**Our Case Number:** ABP-317660-23

**Re:** Bus Connects Kimmage to City Centre core bus corridor scheme  
Kimmage, Dublin

These are the observations of the Metro South West Group on the *BusConnects* Application to An Bord Pleanála regarding the Kimmage to City Corridor. Reference: 317660

### **Assessment of the Passenger Capacity of *BusConnects* in South West Dublin**

Image 2.11: 2028 AM Peak Hour Passenger Volume Along Proposed Scheme (Inbound Direction)

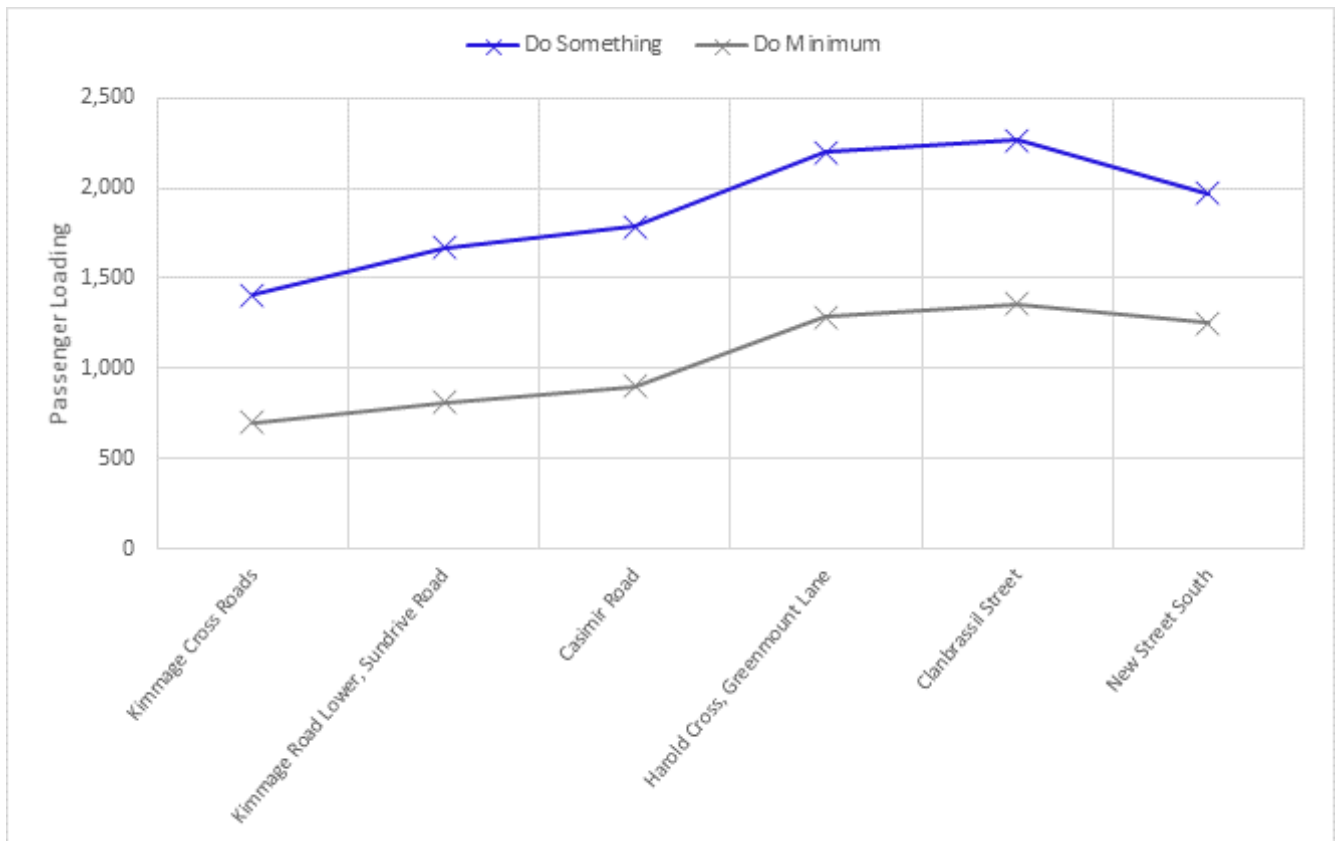
3.4 In their application to ABP, NTA/TII have provided forecasts for the numbers of passengers which are expected to be on board in-bound buses in Terenure Road East from 8-9am. The forecasts are<sup>10</sup>:

3.5 For our analysis, these passenger forecasts are translated into numbers of buses, assuming 50 per cent and 75 per cent average bus occupancy (see para. 2-4-2.7 above). Table 3 shows the results.

The minimum projection in Table 3 is that the number of buses would be more than treble the current situation. Figure 4 shows the data in diagrammatic form for 2028.

If Walker’s projected number of buses in the peak hour (30) was difficult and challenging, what are we to make of the fantastic figures in the last two columns – at a minimum three times the current level – which are implied in the passenger forecasts which have been supplied to An Bord Pleanála? And these buses will be mixed with cars, vans, lorries and bikes on the corridor. Is it the case that the buses which are in excess of Walker (shown in blue on Figure 4) are simply impractical?
